**Land at Bilsham Road, Yapton**  
**Planning Reference: Y/70/22/DOC**

**Approval of details reserved by condition imposed under ref Y/91/17/OUT relating to Condition Nos 9 - surface water drainage and 27 relating to levels.**

**At this stage we would recommend that this condition is not discharged at this time until further information is provided and the comments below are addressed**

CLASS S PIPE BEDDING & SURROUND (NTS)
CLASS Z PIPE BEDDING & SURROUND (NTS)

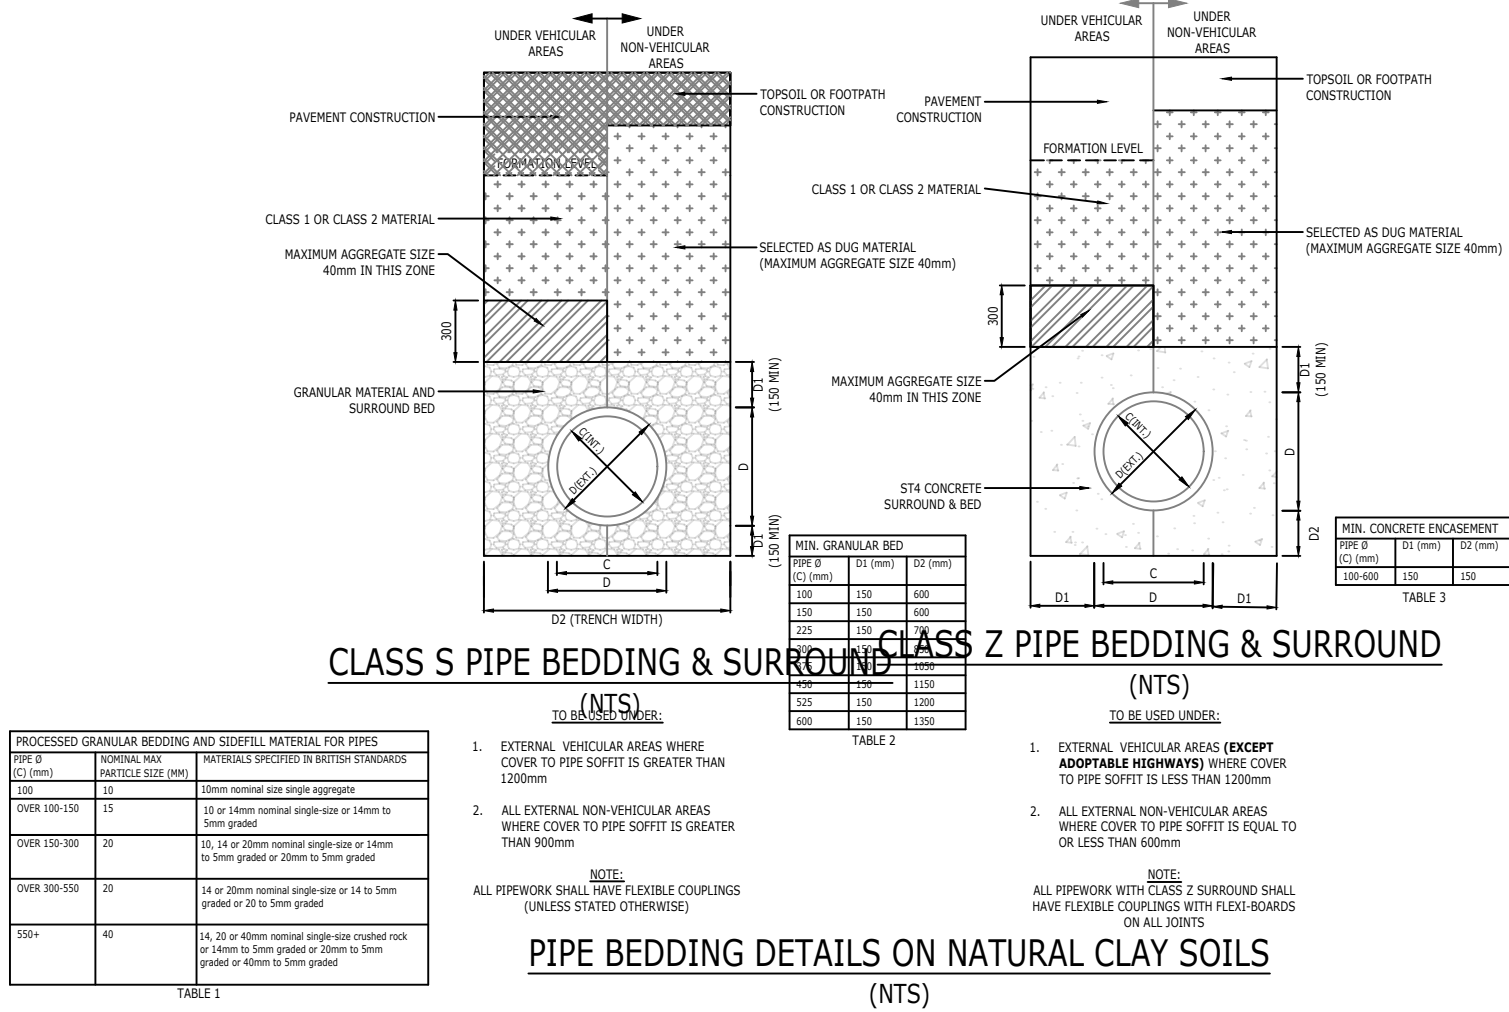
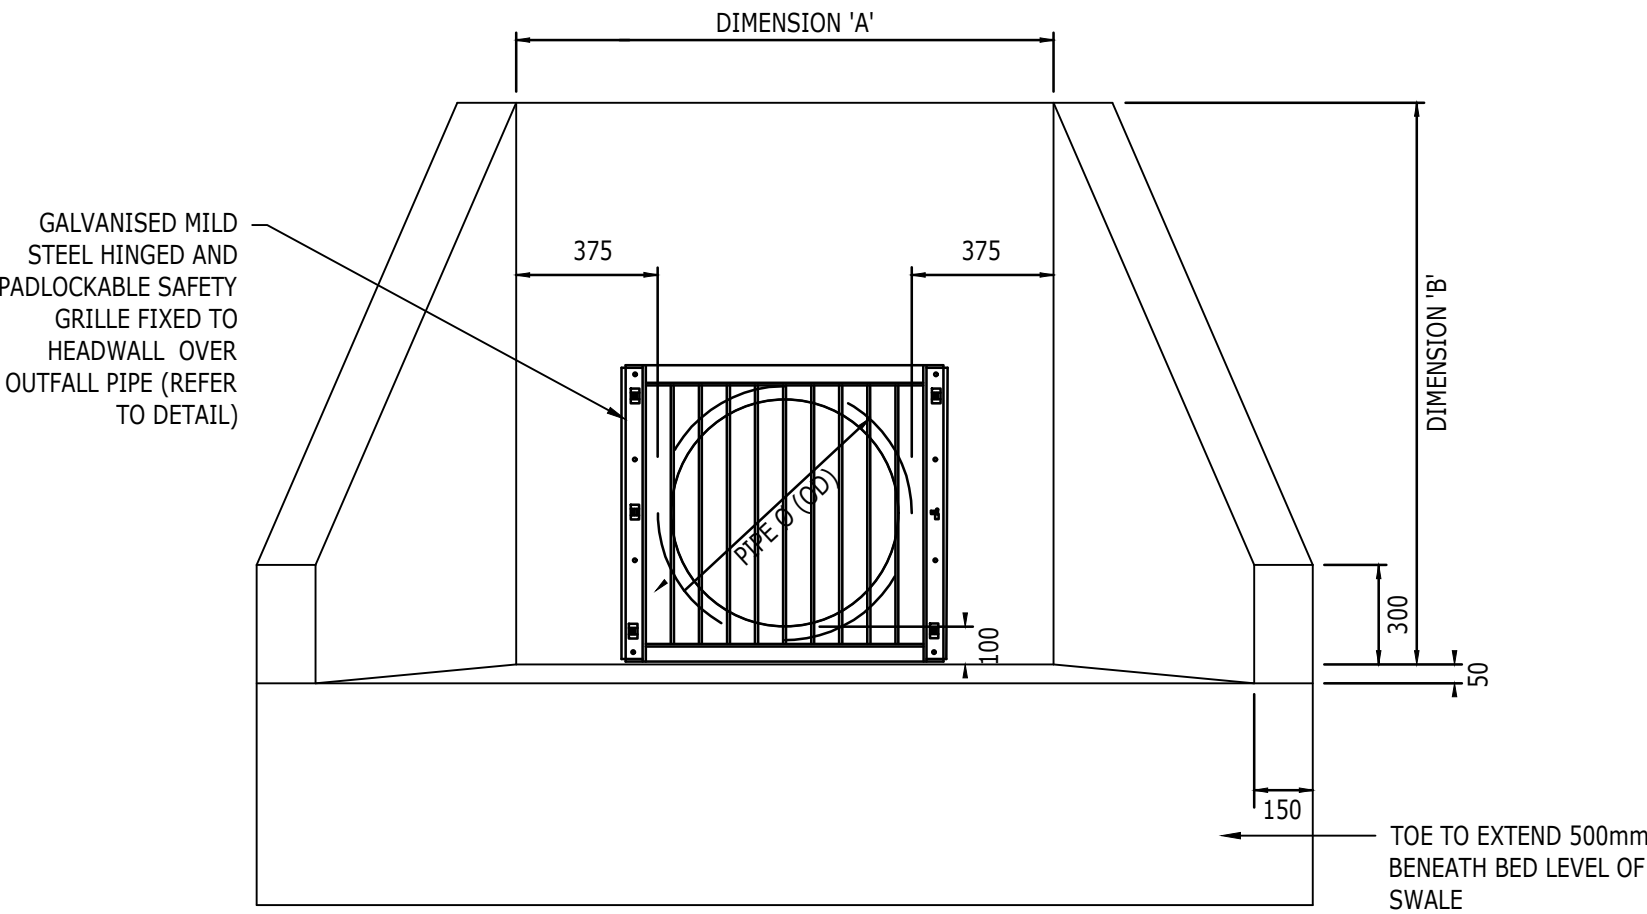
11. *Please provide cranked grilles at a 45 degree angle.* - Cranked grilles required on heads – S104 Construction details sheet 1 of 2 D1956-15-100 needs to be updated to suit ADC requirement. Pipe beddings details on this drawing are illegible in parts. Information needs to be clearly presented. We note that applicant's response that this is not "DSG compliant" however the drawings refer to Sewers for Adoption 7<sup>th</sup> Edition. As such the applicant needs to be clear which edition of Sewer for Adoption the adoptable drainage is being designed to. In addition they should confirm who the adopting authority will be as well as confirmation from the adopting authority on whether they will or will not accept cranked grilles. 08/02/2023- *Whilst is noted that the Technical Approval certificate has been provided for information, this doesn't clarify whether the adopting authority has considered a request to use cranked grilles. This needs to be confirmed by the adopting authority otherwise cranked grilles should be used- 09/07/2023 – We await your submission of the confirmation from the adopting authority or as previously advised this should be amended to meet the requirements of Arun District Council*

Catchpit Installation onto existing run (Bilsham Road, Yapton) – Risk Assessment & Method Statement (RAMS)

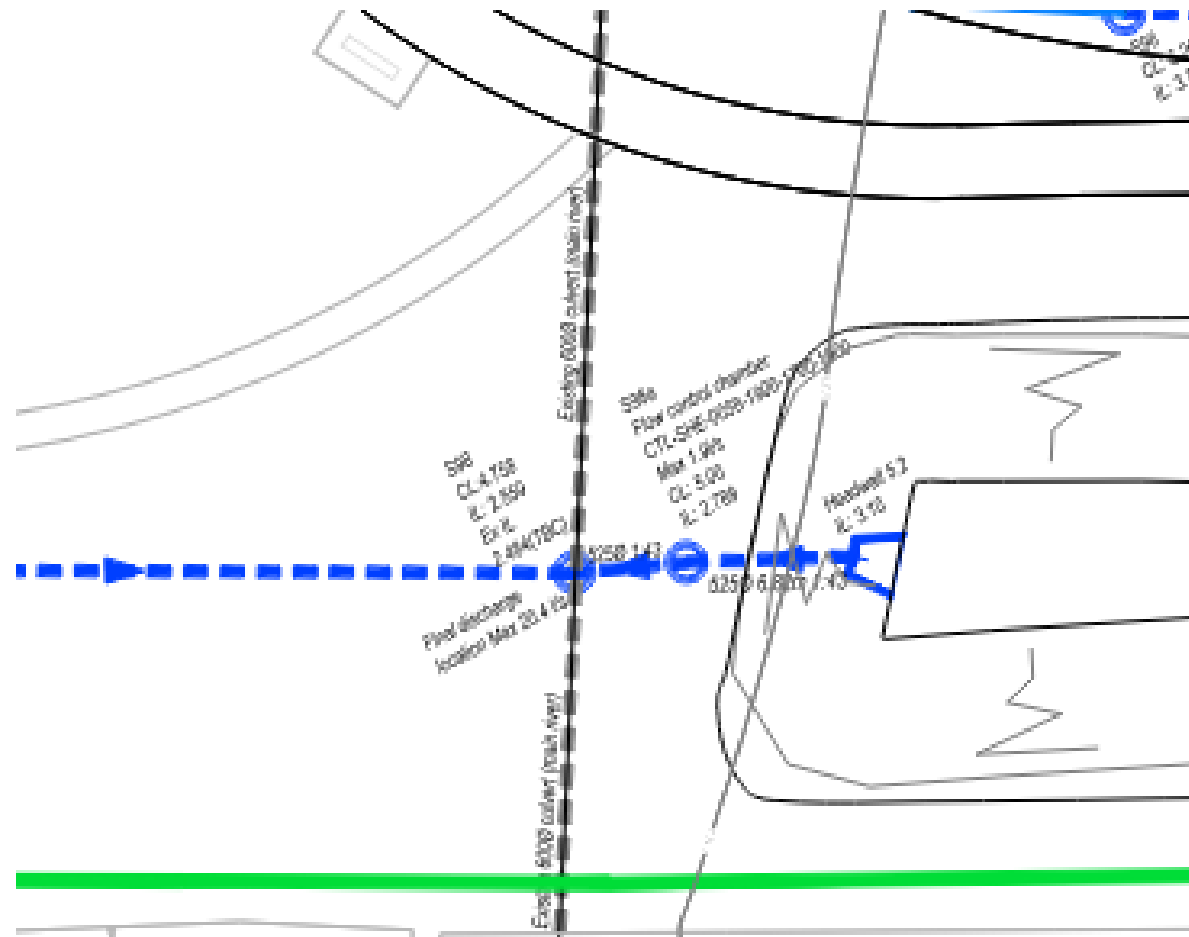
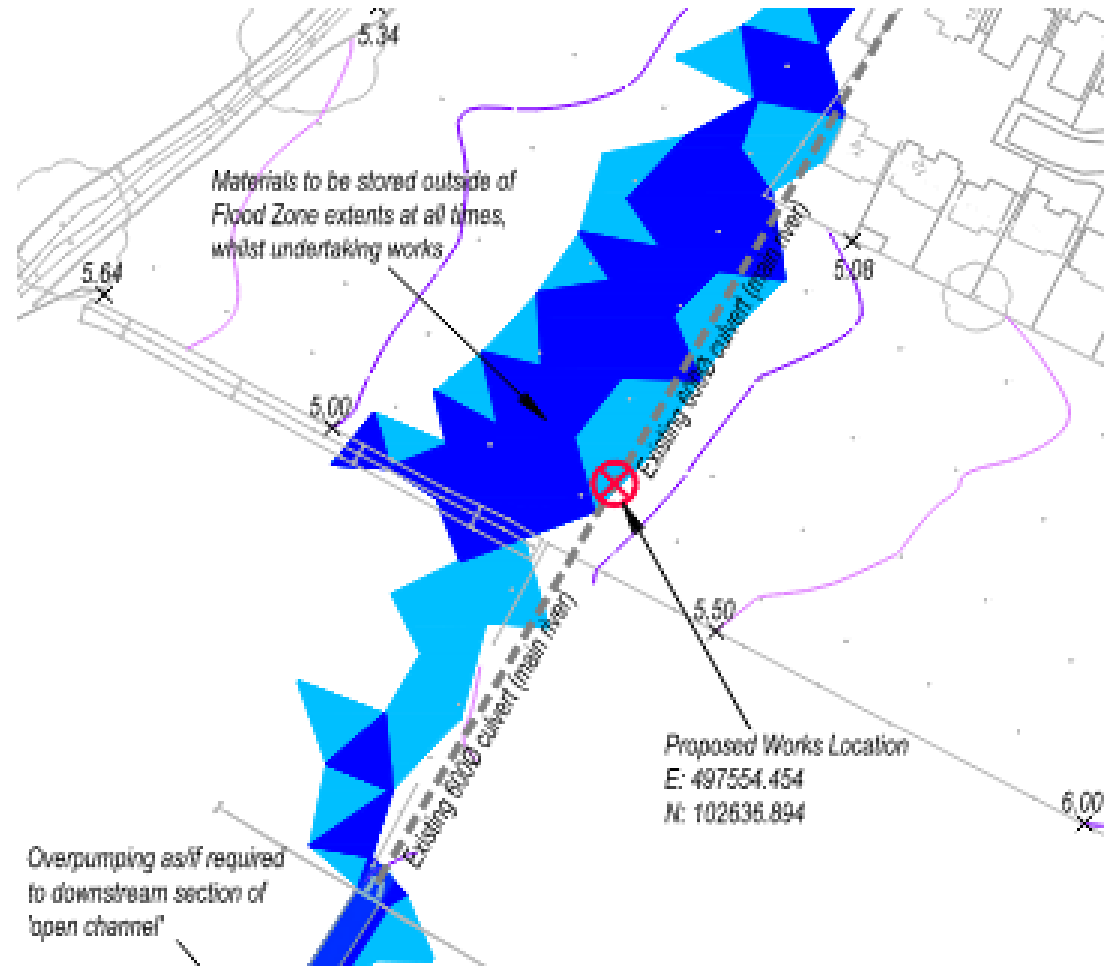
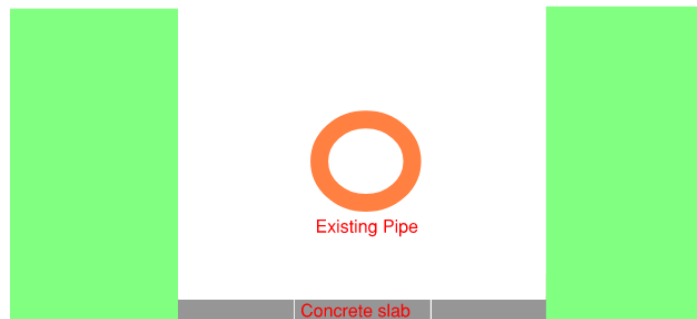
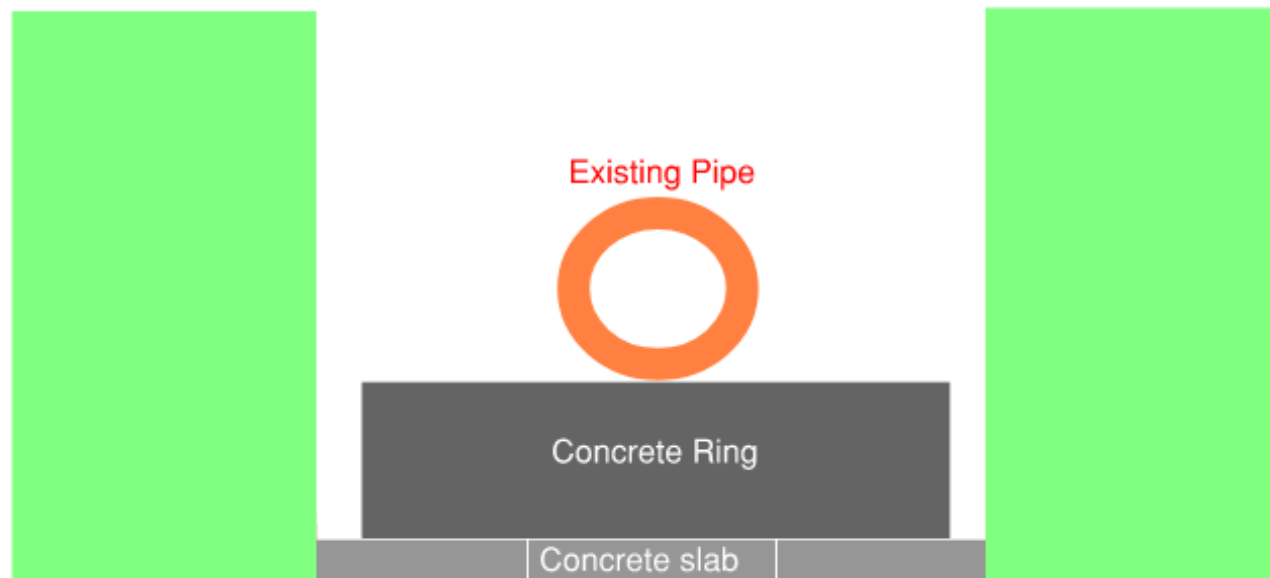
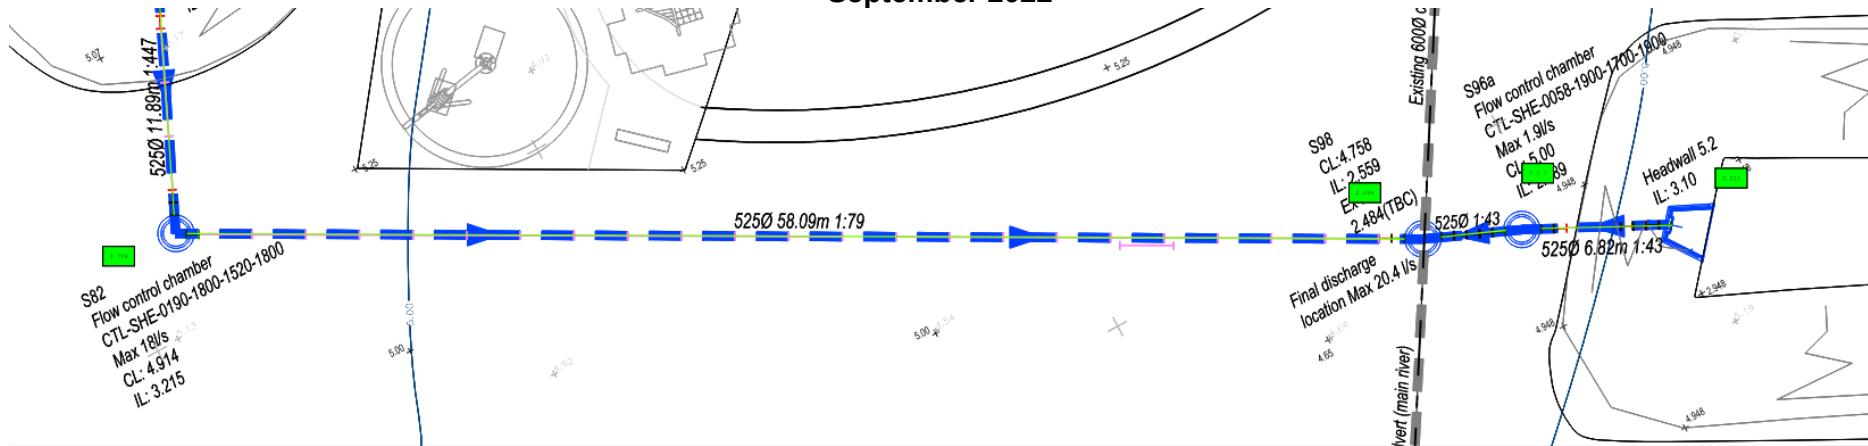
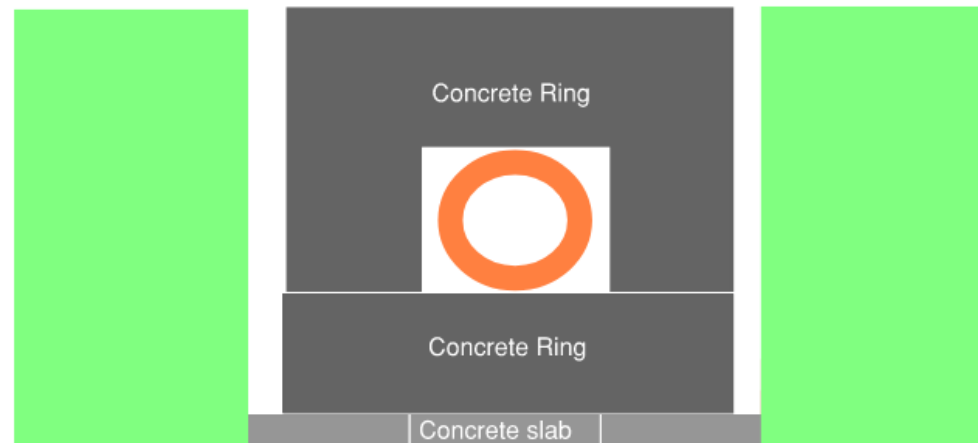
14. *Please provide catchpits upstream of attenuation tanks and basins (unless basins are to have sediment forebays).* - We note that applicant's response that this is not "DSG compliant" however this is not acceptable. The drawings refer to Sewers for Adoption 7<sup>th</sup> Edition. As such the applicant needs to be clear which edition of Sewer for Adoption the adoptable drainage is being designed to. In addition, they should confirm who the adopting authority will be as well as confirmation from the adopting authority on whether they will or will not accept catchpit manholes upstream of the basin or attenuation features. Furthermore, it is evident that the incoming pipe to these basins are at or near the invert of the base of the basin. This means that the inlet pipes will be surcharge for lower storm return periods. The applicant needs to provide confirmation on whether this has been accepted by the adopting authority as well as confirmation on whether the basins are being offered for adoption as well since these are online. 08/2/2023- *This is still outstanding. 09/07/2023 – this comment*

*has not been addressed, provide confirmation from IWNL as to whether or not they would accept catchpits as required by ADC.*
